WEST SUSSEX COUNTY COUNCIL CONSULTATION

TO:	Arun District Council FAO: Andrew Wood
FROM:	WSCC - Highways Authority
DATE:	21 November 2019
LOCATION:	Elm Lodge, Tamarisk Way, Worthing, BN12 5ER
SUBJECT:	FG/141/19/PL Erection of 1 No detached chalet style dwelling with integral garage; demolition of existing conservatory & porches & erection of single storey side extension & part single/part two storey side extension to Elm Lodge (resubmission of FG/220/18/PL).
DATE OF SITE VISIT:	n/a
RECOMMENDATION:	Advice
S106 CONTRIBUTION TOTAL:	n/a

PROPOSED SITE PLAN

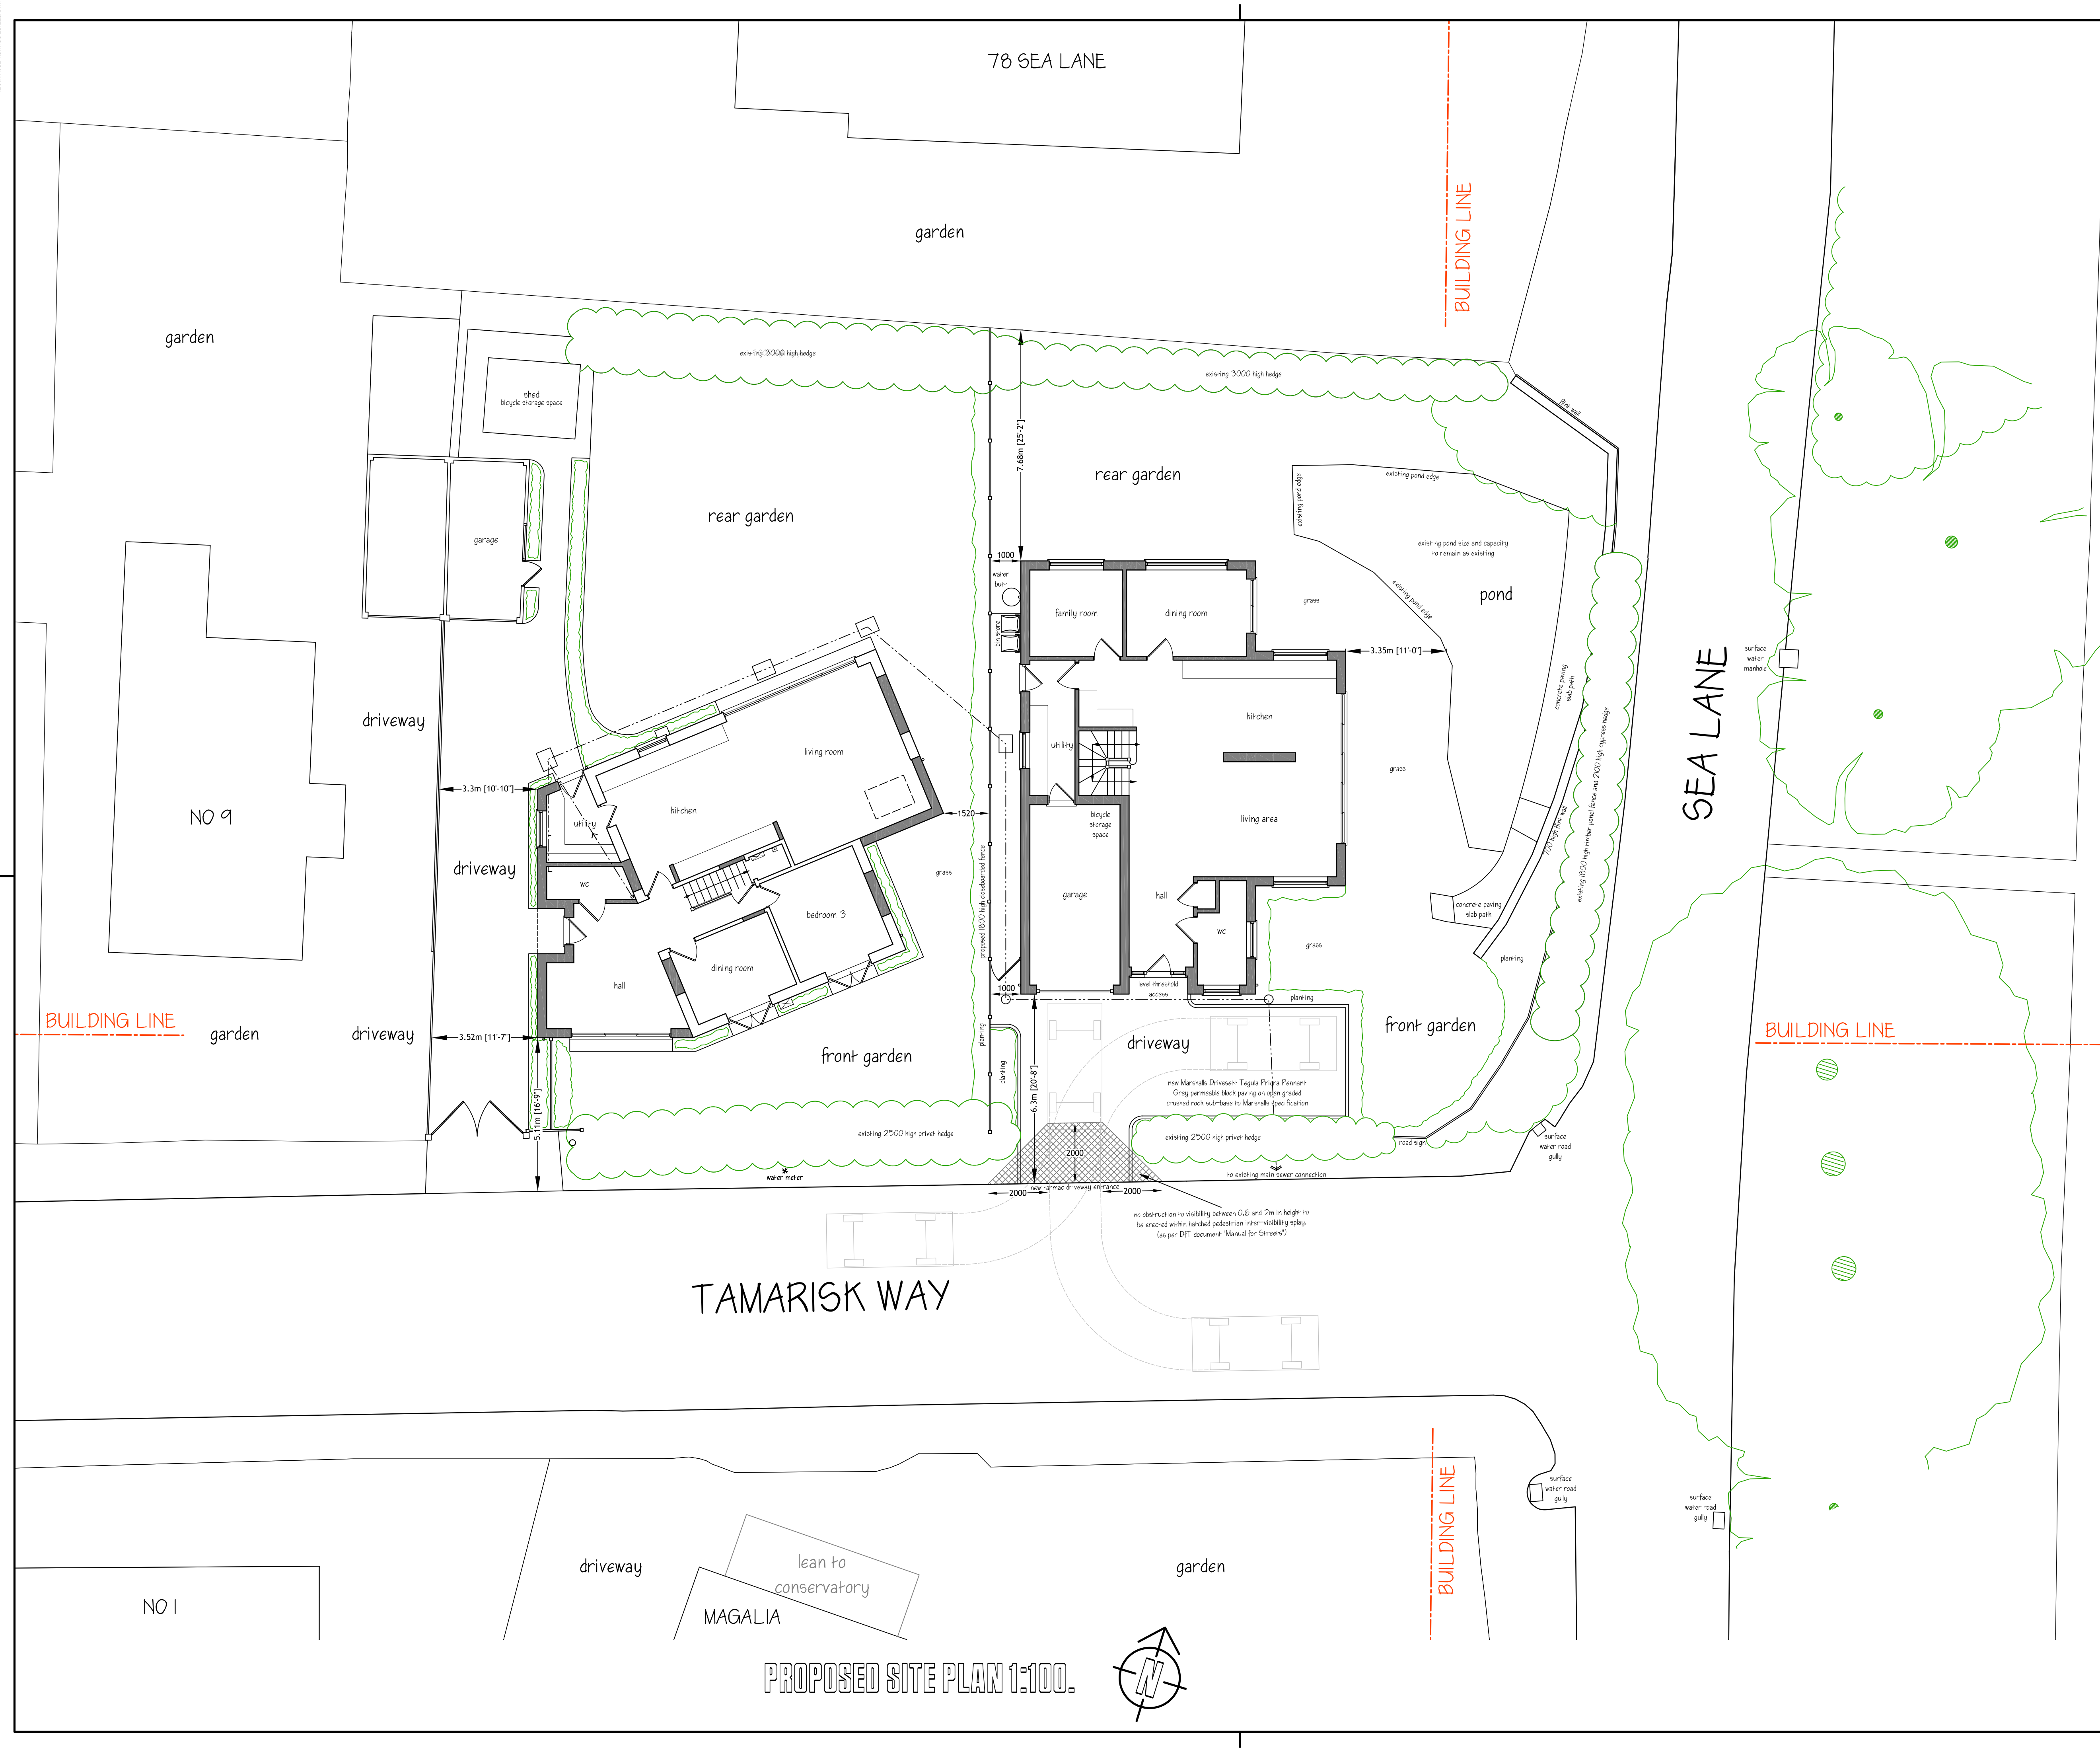
The plans indicate that a new access to the site is proposed for Tamarisk Way. The applicant should obtain formal approval from the proprietor of the private lane to carry out any site access works.

The proposed plans indicate that two off-street parking spaces will be provided for the proposed dwelling and an additional parking space within the proposed integral garage. The plans indicate that the proposed integral garage meets minimum internal dimensions of 3 x 6m as set out in

Manual for Streets (MfS). This level of parking provision is anticipated to be sufficient for a dwelling of this size and location. A turn on site would be preferred however there is clearly insufficient space on site to accommodate this. However, neighbouring properties have similar arrangements and operate without evidence of safety concern.

No part of the development shall be first occupied until the car parking has been constructed in accordance with the approved site plan. These spaces shall thereafter be retained at all times for their designated purpose.

The applicant is advised to obtain formal approval from the proprietor of West Drive for the proposed site access works onto the private lane.
